From: Christopher Davis
Sent: 20 September 2018 13:27
To: [REDACTED]
Cc: Anna Appleton; Anita Gardner
Subject: RE: EP/107/18/NMA - 3 THE STREET EAST PRESTON - ASHP
Importance: High

From: K.A.L HOMES LTD [REDACTED]
Sent: 19 September 2018 12:01
To: Anna Appleton
Subject: EP/107/18/NMA - 3 THE STREET EAST PRESTON - ASHP

Proposed Site Plan @ 1:100

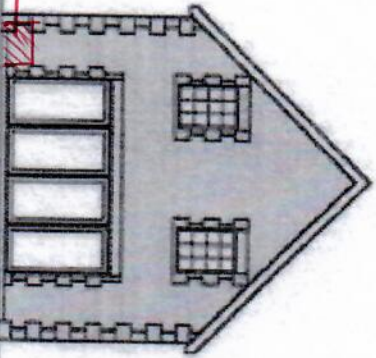
I understand from our planning application that you have issues relating to the positioning of our ASHP units, glazing etc...

The positioning of plot 1 - is the only place the unit can be positioned on the building due to the drive and wall on the other side.

Plot 2 ashp again we believe to be in a good position as the unit is the smallest that they make and it is again mounted on flexi feet.

It was good to meet you on site this morning and thank you for arranging for the ASHP pumps to be running on each plot so I could make my acoustics assessments accordingly

Having assessed both plots, I can confirm that neither of the ASHP pumps create a level of noise that would be deemed a nuisance, intrusive or loud enough to create a disturbance to either the residents of the homes or the neighbouring dwellings
